From: Andrew Wood
Sent: 15 March 2019 16:19
To: Lynnyrd Wolfe
Subject: FW: Planning Application FG/220/18/PL : Land adjacent to Elm Lodge, Tamarisk Way, Ferring, West Sussex BN12 5ER
Attachments: Revised Site Plan 22.2.19.pdf; Land Registry Scan 1983.pdf; Documents emailed to Laura on 19.2.19.pdf

RE: Planning Application FG/220/18/PL : Land adjacent to Elm Lodge, Tamarisk Way, Ferring, West Sussex BN12 5ER

PROPOSED POND ACCESS
PLAN

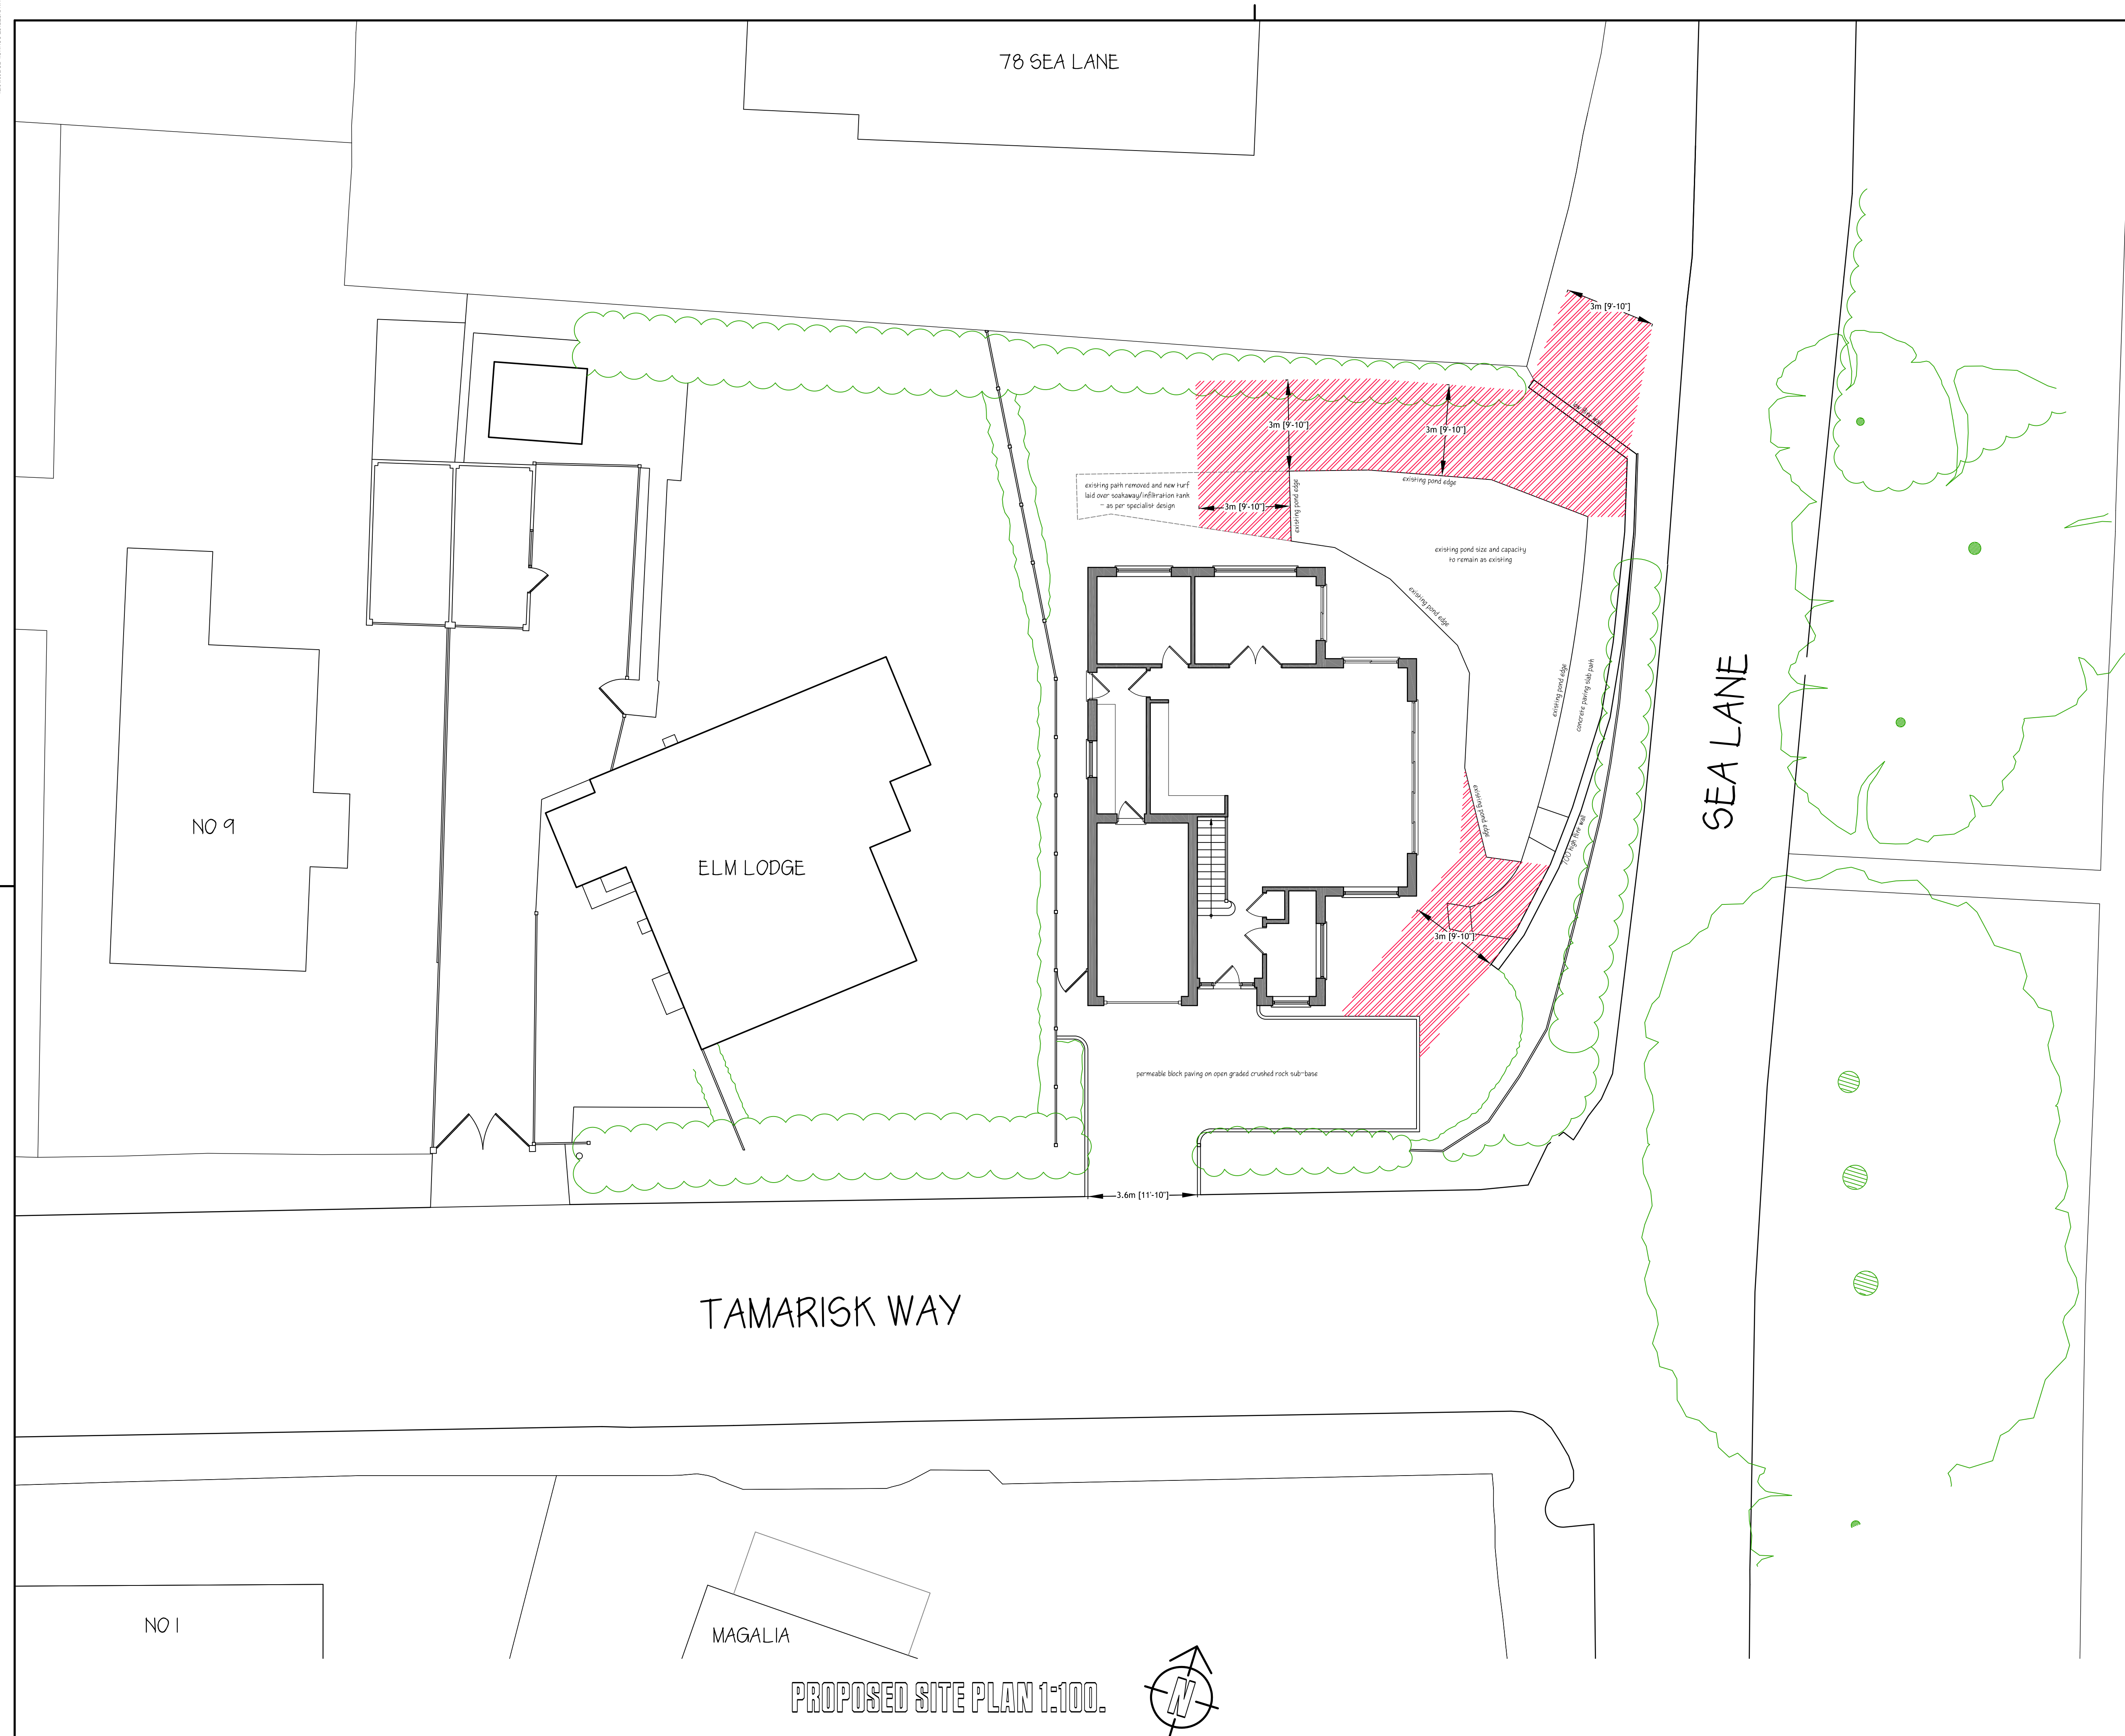
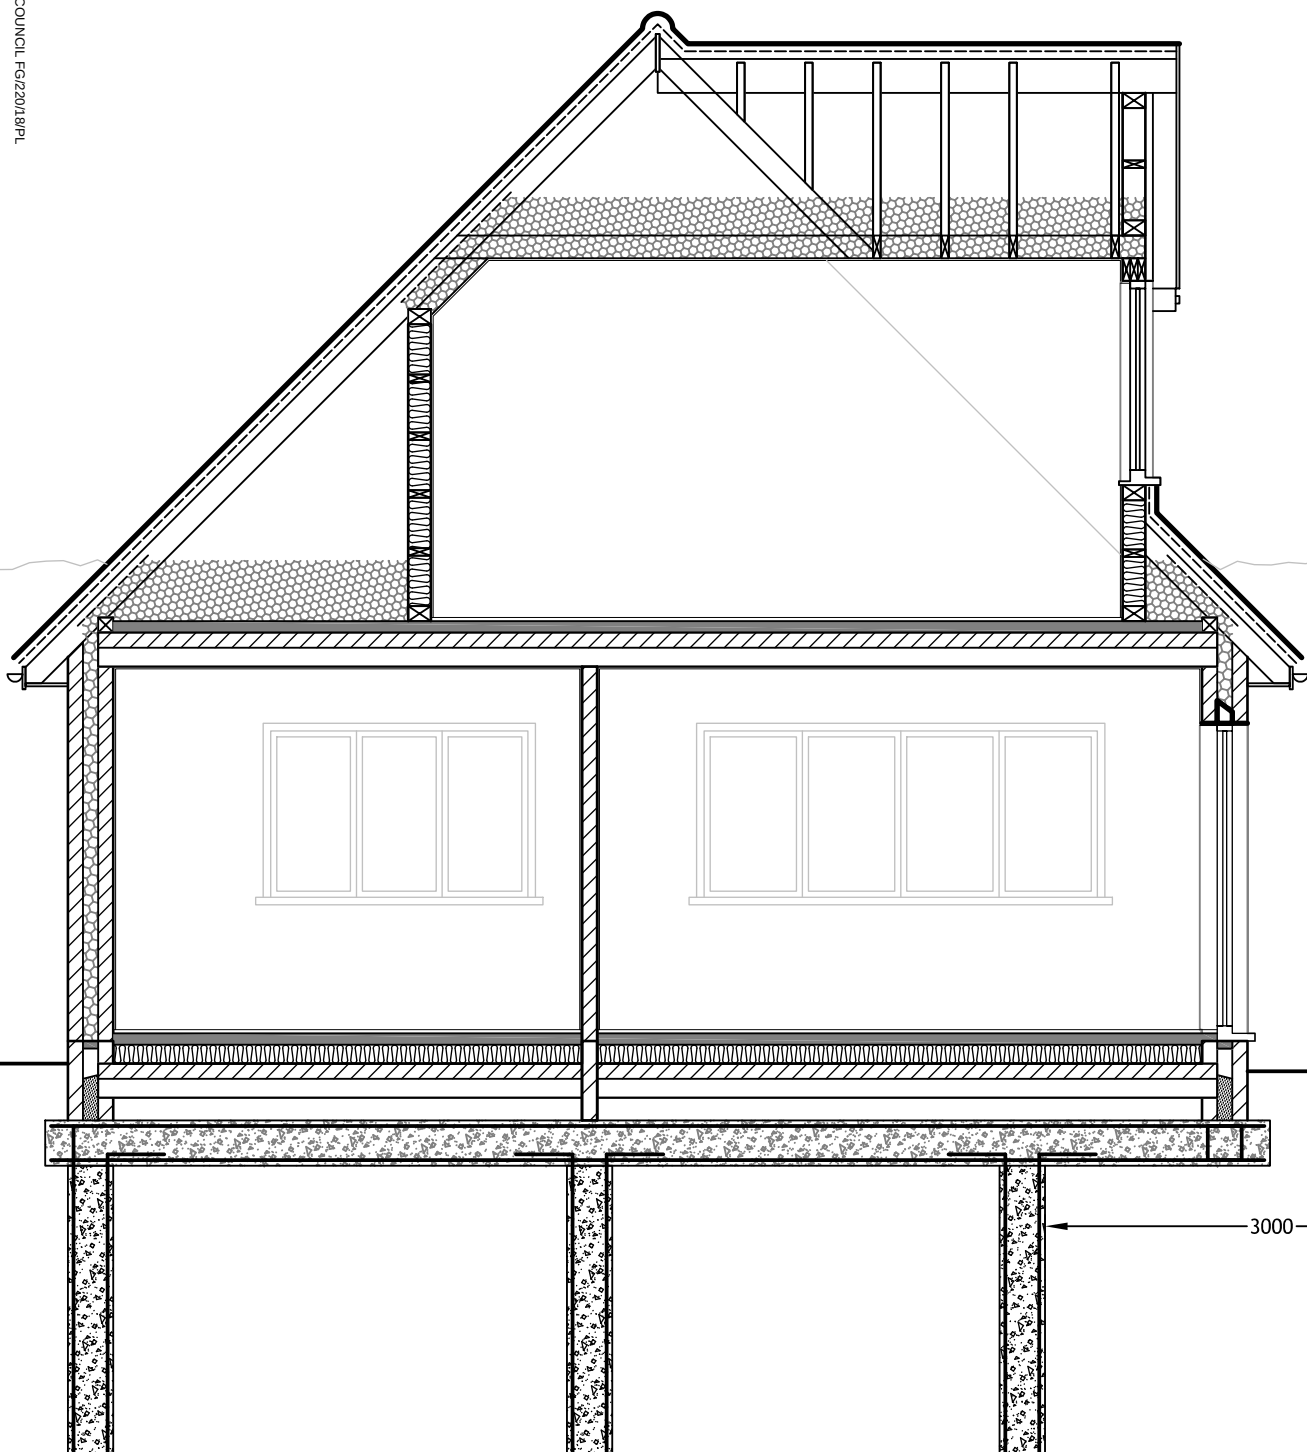
2. I am not keen to see the building go up to within 0.8m of the pond. Access and erosion are both a concern. I would therefore be keen to see the building layout revised to provide more easement. As shown on the proposed indicative part foundation section detail, short bore piles would be positioned a minimum of 3m from any edge of the pond, reducing the risk of erosion by eliminating trench foundations. Given a specialist would be designing the reinforcement/camp shedding for the existing edge of the pond (again, to be agreed with ADC by condition prior to commencement), this would ensure there will be no erosion. Given the building would only be cantilevered at one point within 0.8m of the pond, there is still a large area of access around the east and all other parts of the pond. We note that ADC has never had to access the pond to carry out any maintenance works to date, therefore query why there is such an onerous requirement for access now. We also note that ADC cannot currently access the pond with plant, since we have gates to the property and a further gate at the rear which would obstruct machinery from accessing our garden to carry out any maintenance works at all. ADC would have greater access to the pond as a result of the proposal, given there would be no obstruction when entering from the driveway. ADC Bylaws state that "Riparian Owners are responsible for maintaining the watercourse and any associated structures (i.e. headwalls, screen, weir etc.) and primarily to keep them free of any obstructions that may impede flow in the watercourse". There will be no obstructions which impede the flow in the watercourse, as demonstrated. We can easily complete any pond works to ensure it is upgraded from its current state (which has not been identified as obstructed or badly maintained by ADC to date) before commencement of any building works on site. The bylaws state that "Arun District Council may decide to exercise the permissive powers if it is approached by property owners affected by badly maintained or obstructed watercourses and they have been unable to get a 'riparian owner' to carry out necessary works. In the first instance, Arun District Council will try to resolve the problem informally by explaining 'riparian ownership' responsibilities and agreeing the work that is required to the watercourse to rectify the problem. If this approach is unsuccessful, Arun District Council may require and enforce 'riparian owners' to carry out works using powers under S25 of the Land Drainage Act 1991 where the flow of water is impeded and the condition needs to be remedied." Given we as riparian owners will be able to access the pond from all sides to carry out any works in accordance with the bylaws, we do not understand why ADC would need access to our land, particularly from multiple different points given they cannot access it at all at present. It is the landowners (Riparian) responsibility to complete maintenance works, if we are informed of an impediment to flow we request landowners complete this maintenance. If they refuse to complete the work, we use our powers under S25, and this can be accompanied by forced entry through gates. The proposed layout will make it exceptionally difficult to complete maintenance. Irrespective of planning it is fairly evident that an impediment to flow is present, so we will be requiring you as landowners to complete maintenance to the pond to ensure silt levels are reduced and culverts are in an appropriate condition. Ongoing maintenance (including to any retaining walls) will be required after construction is complete, this is when the proposed site layout in my opinion would prevent this work.

3. It is my belief that there is no way to get to the northern and western portions of the pond without tracking through the pond itself. This would mean that maintenance would have to be completed in the summer by the landowner when water levels are lower. This would then be within nesting bird season. I would much prefer an access to be provided around the pond. I note that you state the 1m wide path to the east could take plant but this plant would not be big enough. As explained above, we as landowners can continue to access the pond from all sides, with 3m to the West, North and South East. We cannot understand what plant would ever be required (given no plant has ever needed to access the pond before, and any plant necessary for carrying out works to the pond can have full access from all sides as part of the building works) that would ever be larger than a small digger, which can easily be maneuvered up the 1m side access to the west of site and around the rear. You are going to need a large digger to access the pond and clear it of vegetation and silt. The size of machine is dictated by the depths that excavation need to be carried out to, the size of plant that can fit along a 1m path would not be sufficient to carry out the excavation required. Ongoing maintenance will be required after construction is complete, this is when the proposed site layout in my opinion would prevent this work.

Further to our meeting at the land adjacent to Elm Lodge, Tamarisk Way, Ferring, West Sussex BN12 5ER on 12th February 2018, please find attached the existing and proposed pond access plans as requested. These show the existing pond to be retained in its entirety, with 3m access provided should Arun District Council ever need to access our property to maintain the pond. We hope these now alleviate your concerns regarding potential future access. We also note that the path to the east of the pond is also over 1m wide, which can currently comfortably accommodate a 1.5 ton digger to carry out any works. Given that there are multiple points of entry along the edge of the pond, any further work can be carried out from within the pond.

We also attach an indicative proposed part foundation section detail to show proposed short bore piles a minimum of 3m from the edge of the existing pond. There will be no encroachment or structural implications for the pond.
